Major Projects Assessment,
Department Planning,
G.P.O. Box 39,
SYDNEY N.S.W. 2001

**RW: Application No 09-0166, 320 Lot Subdivisions,
Fraser Drive, Terranora N.S.W. 2486**

BROADWATER PARKWAY
LAYOUT

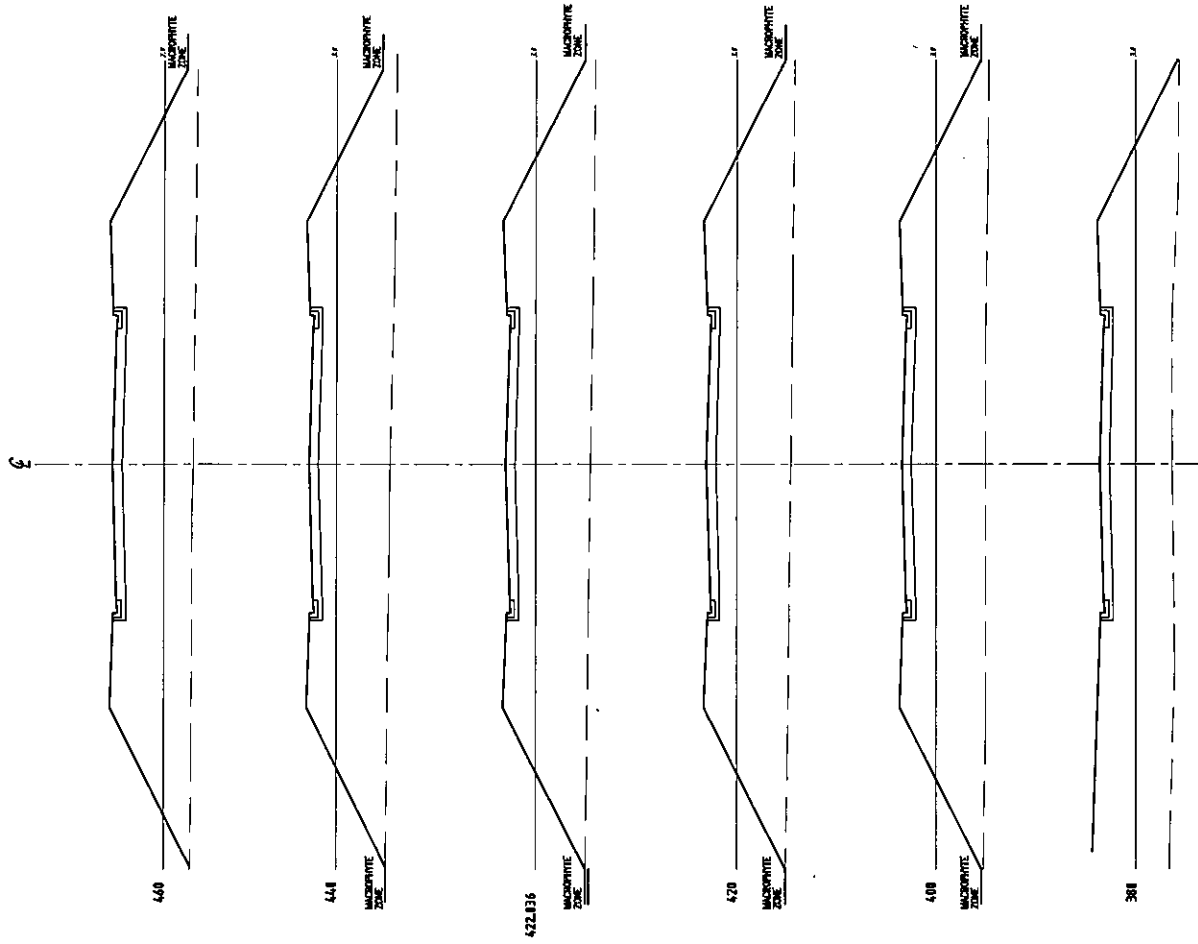
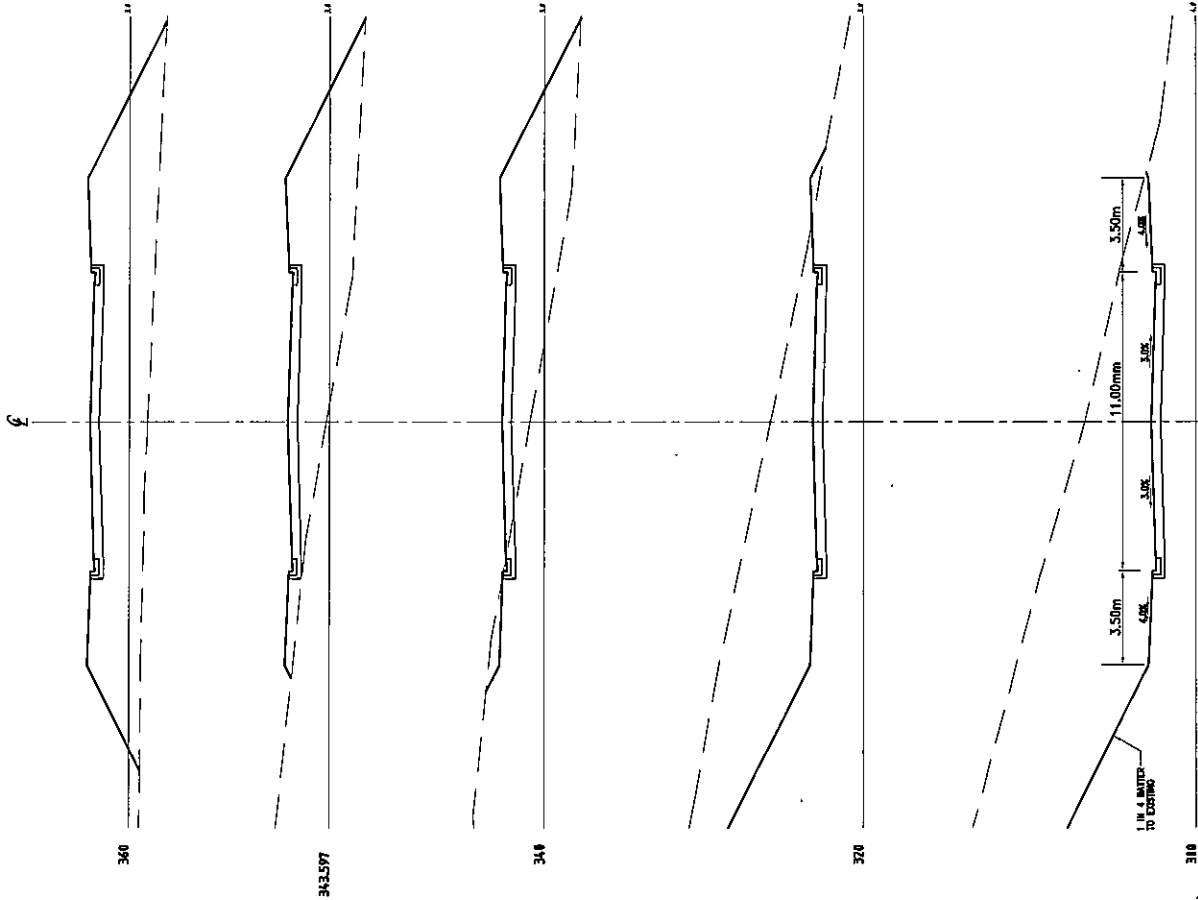
The Parkway is presented as a two-lane configuration. However, the traffic predictions by Tweed Council is for volumes 11,800 vpd. Reference to Tweed Roadworks Standards depicted in drawing S.D. 002 dated 2004, shows that a

normal neighbourhood collector road should cater for up to 7,000 vpd, while volumes in excess of 7,000 vpd require a four lane facility with median strip.

It is submitted that the application cannot be rationally determined until the parkway alignment and design is completed, and the public are given time to inspect and comment. Meantime the application must be deemed to be incomplete.

In regard to the general alignment location approaching Fraser Drive, it should be noted (as referred to in the application) that four properties will be involved and basically destroyed by encroachment of massive batters, loss of amenity and subjection to excessive traffic noise from the steep grades, should the road be constructed in this vicinity.
